**Berkshire, Buckinghamshire &  
Oxfordshire Wildlife Trust**  
The Lodge, 1 Armstrong Road,  
Littlemore, Oxford, OX4 4XT  
Tel: 01865 788300 Fax: 01865 711301  
Visit: [www.bbowl.org.uk](http://www.bbowl.org.uk)

**OBJECTION Re: 14/02121/OUT Development proposed at Himley Village, North West Bicester**

Drawing Title
Landscape - Parameter Plan 3

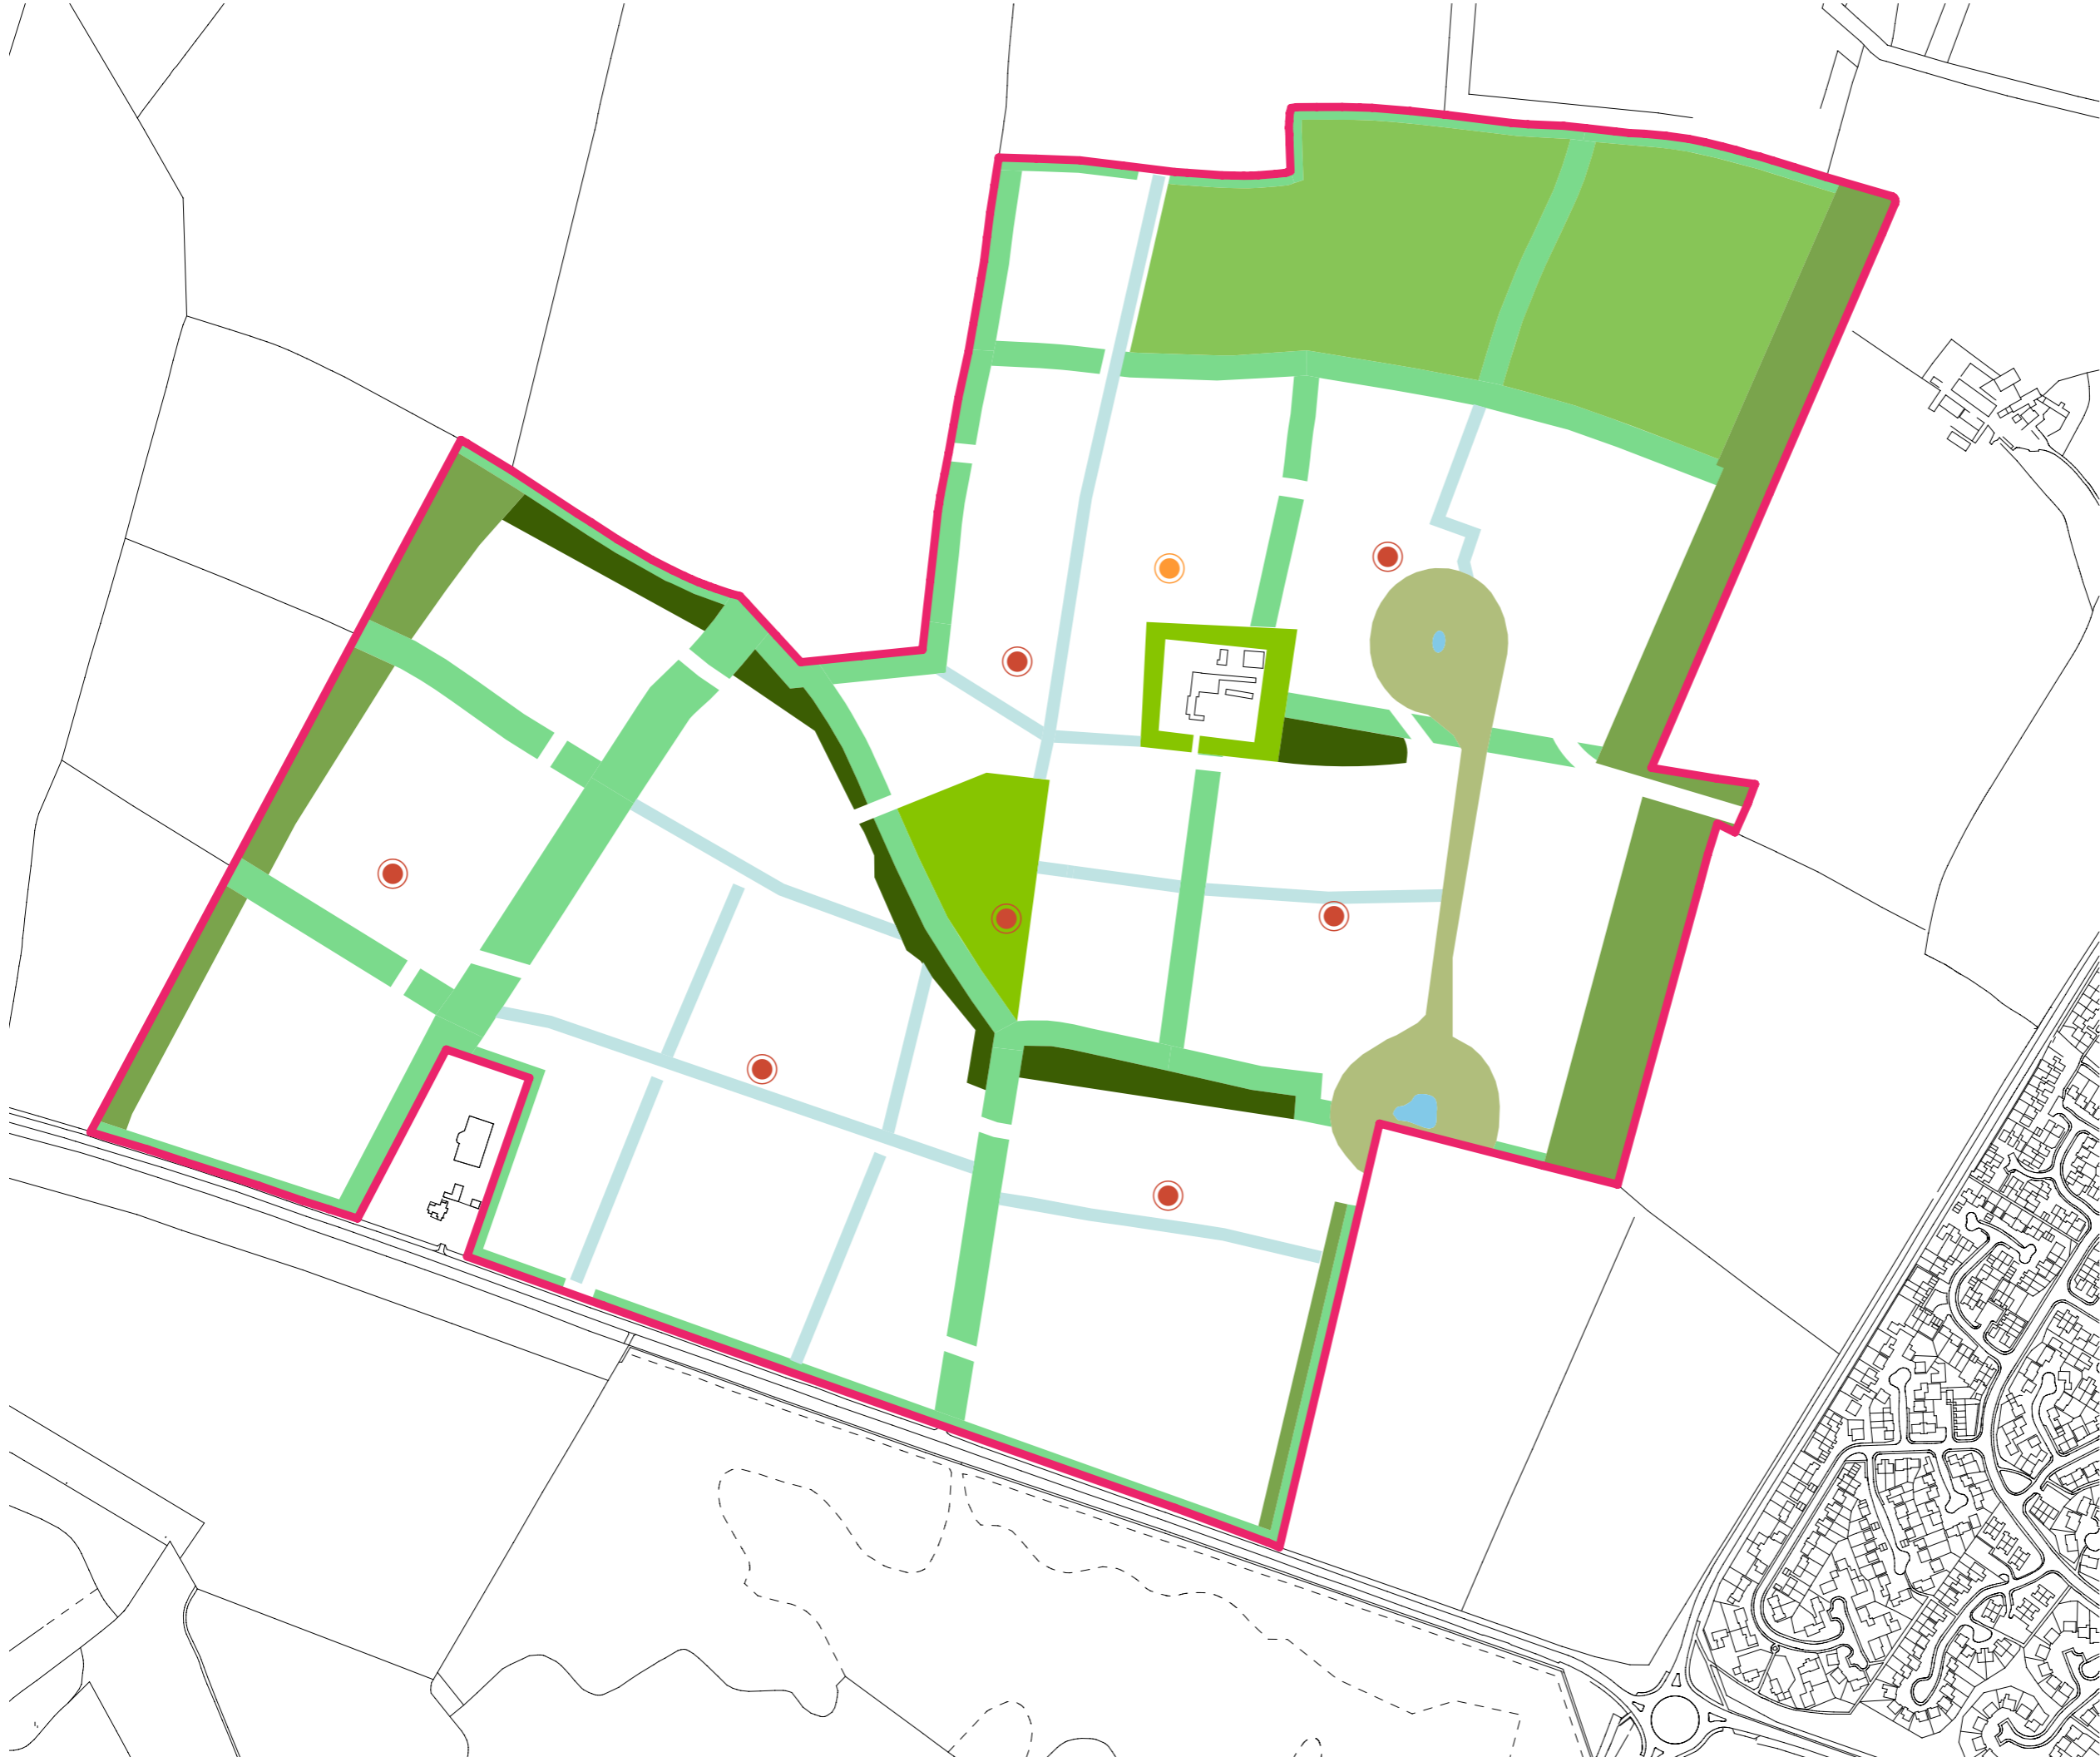
We welcome the clarification provided by the addendum to the ES to confirm that a 10m buffer will be provided either side of hedgerows, and that a 40m wide dark corridor will also be provided. I suggest that these standards are secured by planning condition.

However, Section 5.3.1 the Biodiversity Strategy for the Masterplan site also identifies the need for a 50m buffer around the newt ponds found within the Himley Village area, and I have found no reference to this within the application materials. I therefore maintain an objection due to lack of compliance with standards set out in the Masterplan.
